ABP-310352-21 (Sligo) A. Doherty

From: Bord
Sent: Tuesday 20 July 2021 16:01
To: Appeals2
Subject: FW: Re exempted development Ed 420 for 14 the drive
Attachments: response letter 9.7.21.pdf

RE: Exempted development ED 420 for 14 The Drive, Ocean Links

Client: Stephanie & Dominic Galwey	Drawn By: JFK
Project: Alterations to Dwelling at 13 The Drive, Ocean Links, Stranhill, Co. Sligo.	Scale: 1:100
Title: Proposed Ground Floor Layout	Date: Feb. 2020
Drawing Status: <b>FOR TENDER</b>	Drawing No: <b>1-02</b>
	Rev: <b>C</b>

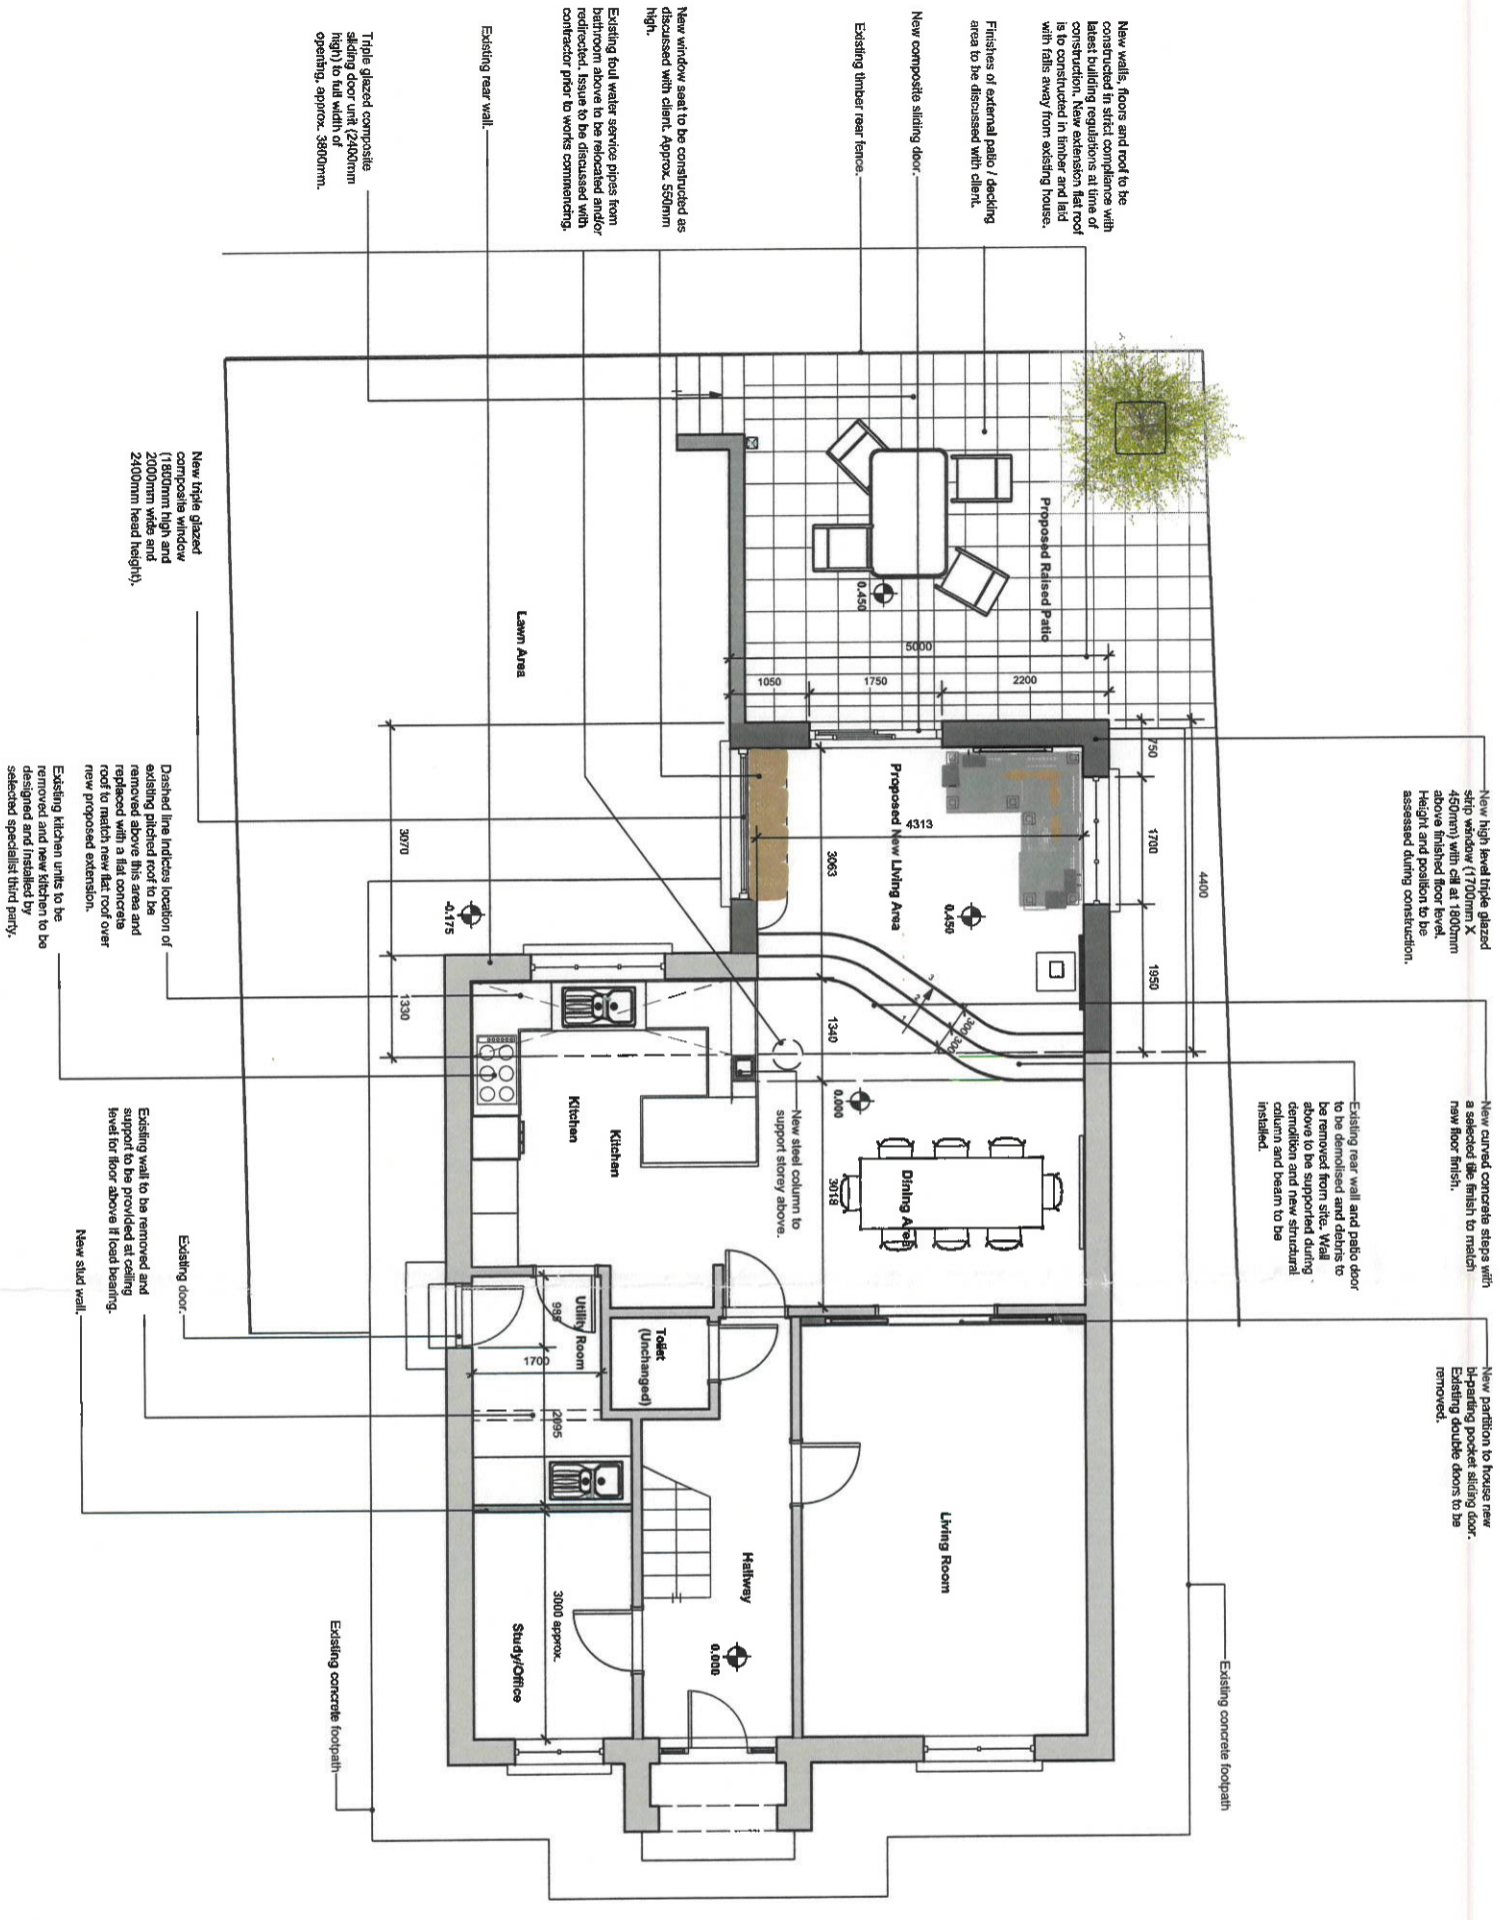
- 1) The extension steps up 0.45m (c. 1.5 foot) to a floor which is 1.5 foot higher than ground floor. Whilst Terranova note that our neighbour's property is lower than 13 the Drive, this does not change my interpretation that the Galwey's will be stepping onto a different floor. Could Terranova, please clarify how a 1.5-foot jump is going to be made from the existing ground floor to the new floor as I would expect steps will need to be installed to get to this level strengthening my view that it is another floor to the house/extension.

Drawing Status: FOR TENDER  
Drawing No: 1-03  
Rev: D

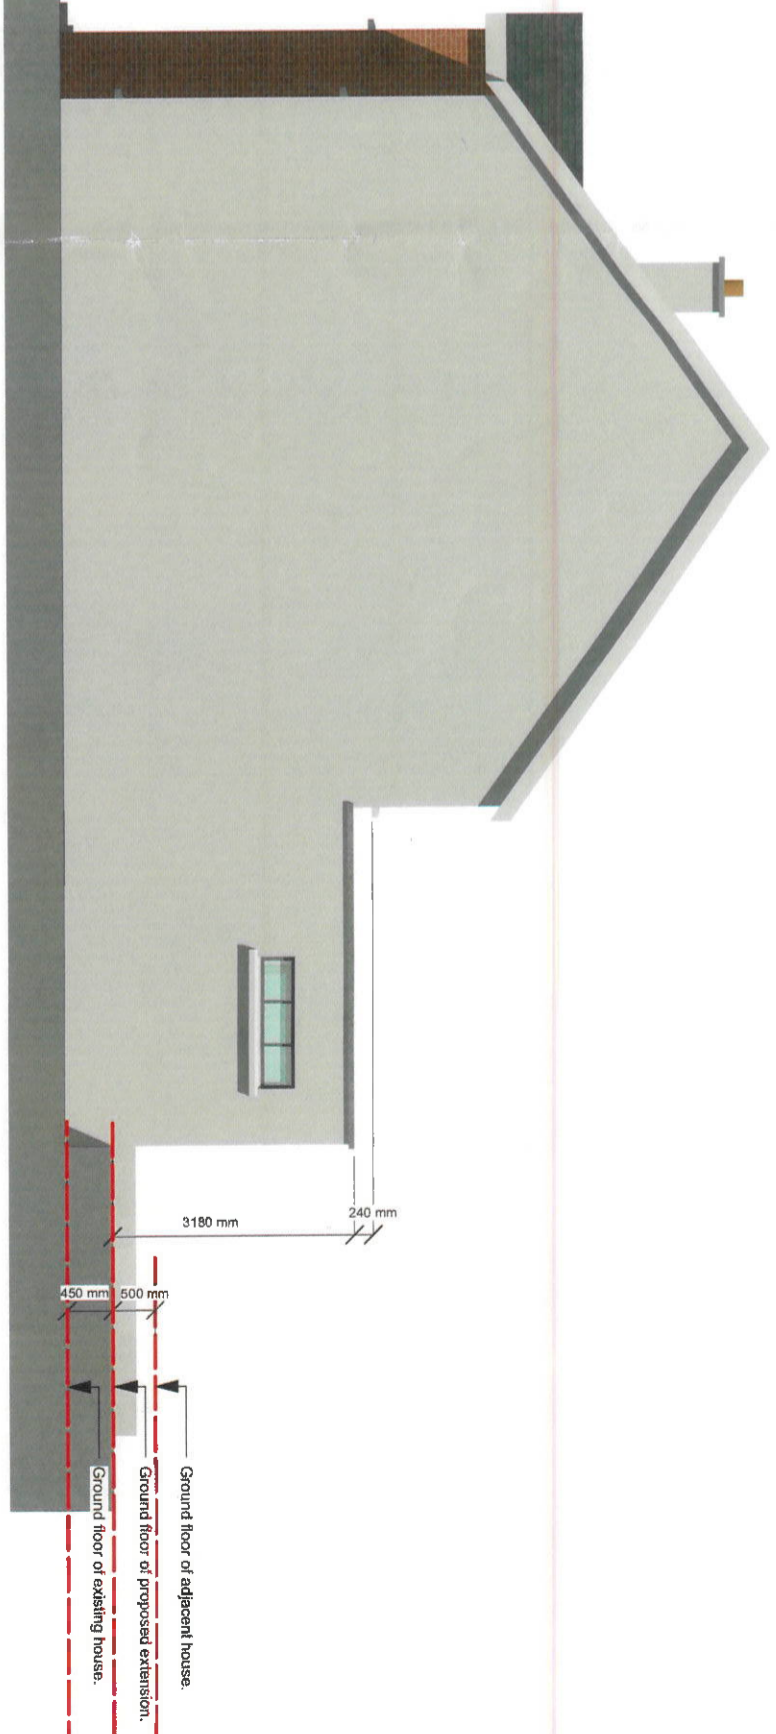
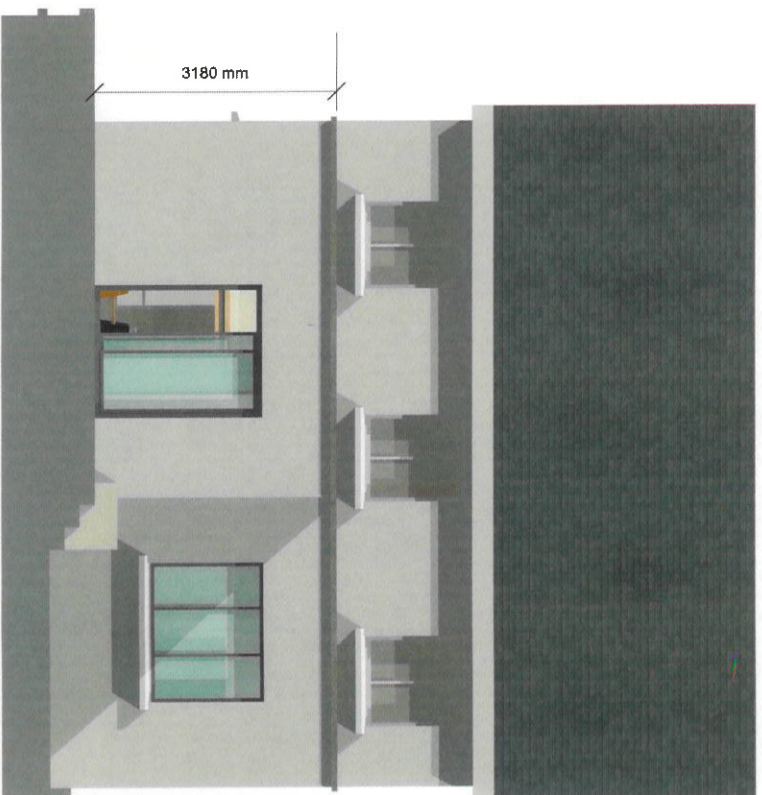
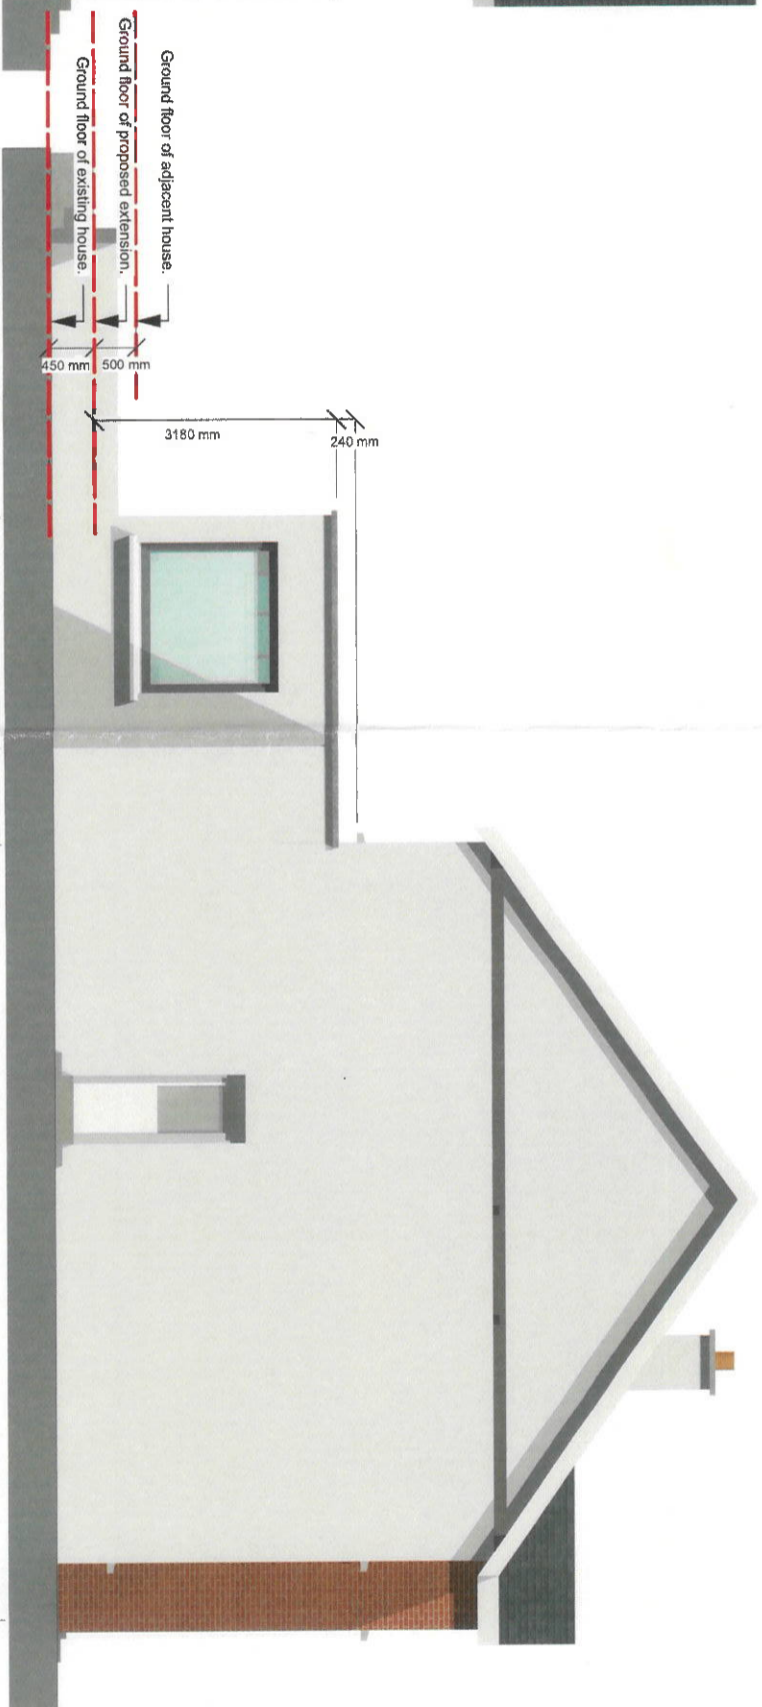
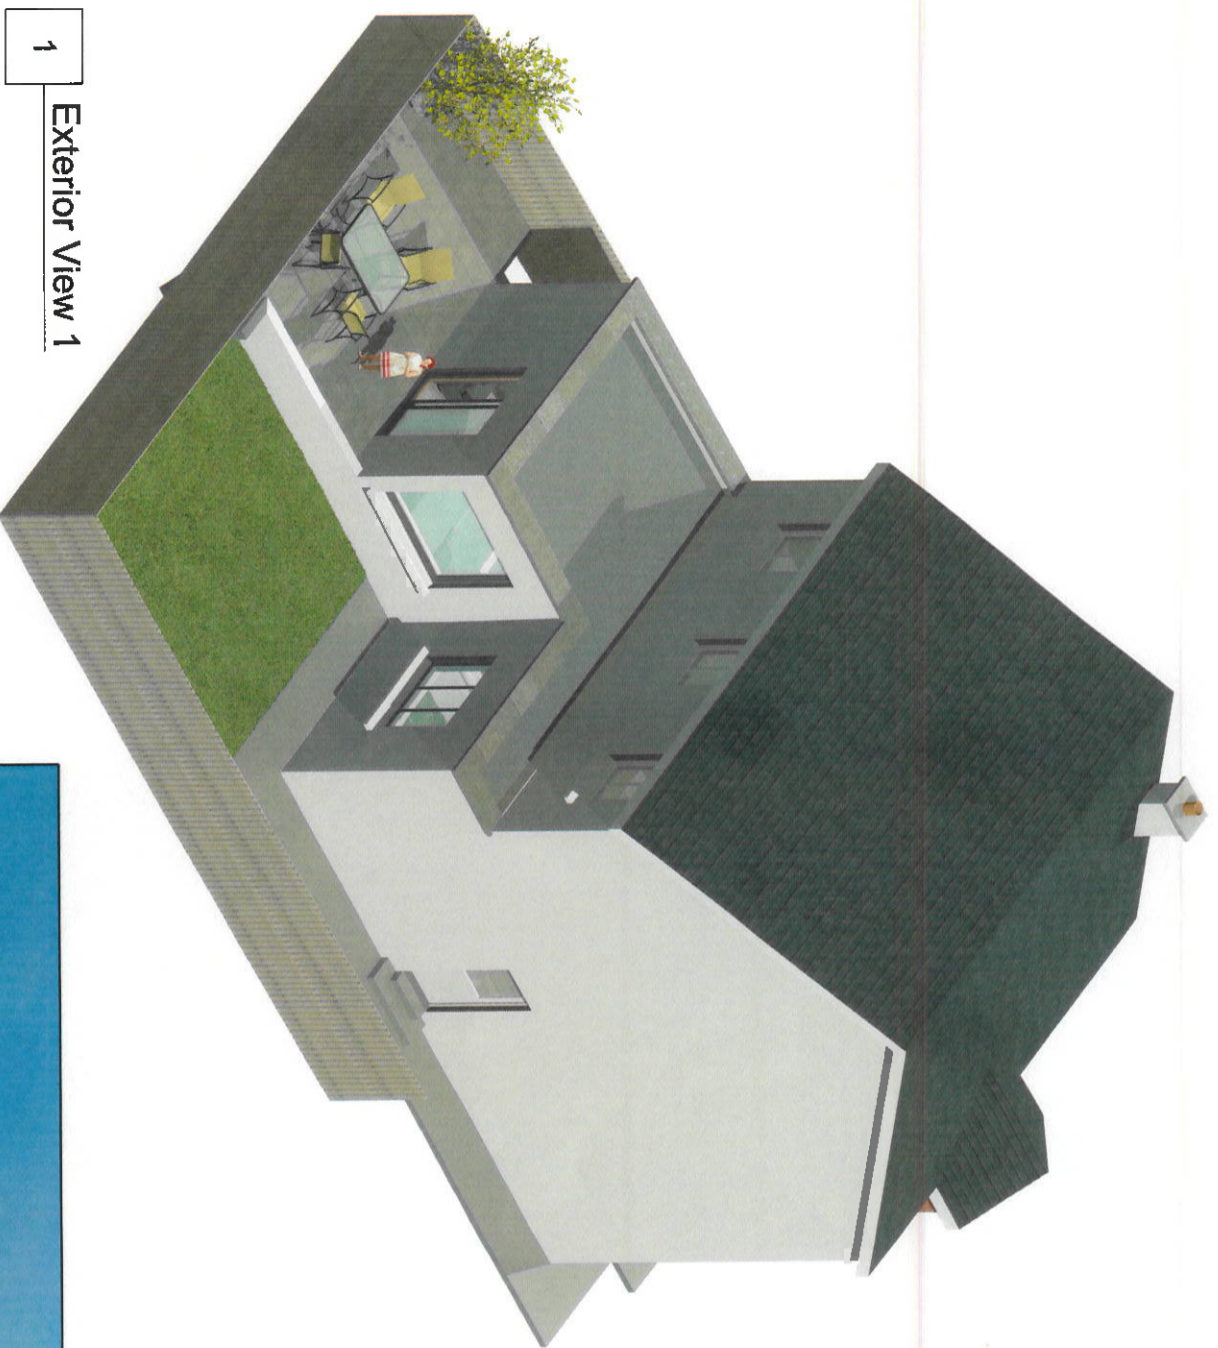
I would like to reiterate that, per Government planning guidelines, once you go above a single storey which I deem this to be, their needs to be 2m (6.6ft) from your neighbours boundary and there is only 5.6ft from our boundary fence. The proximity to our garden is covered in point 2 of the letter.

I still have an issue with a window which will be on the side facing our garden given Terranova note the difference in site levels and it is also referred to in government guidelines.

- 2) Due to the proximity of the 12 foot flat roof (3.1m) – c. 5.6 feet from our boundary fence , we feel that it will lead to a loss of light and overshadowing into our garden. The extension will block our evening sun which makes its way around to our property at c. 6pm – 8pm and it is very hard to determine what drawings Terranova have provided actually prove given they are computerised and therefore not accurate reflection of real life events. The inspector will be able to make their own assessment and the proximity to our garden on their site visit.
- 3) Terranova note that they do not understand our comment “not inkeeping with the estate”). We are very firm in our belief that the very bulky flat roof extension and does not fit into the landscape in Strandhill which is a place of natural beauty with the sea one side and Knockarea Mountain the other side.

The extension in its current state will be visible from 7 rear gardens in our estate and will either block a sea or mountain view. All of the other extensions along this row are of a hip roof nature and complement the landscape better and are more inkeeping with the estate than a bulky 12 foot flat roof extension.
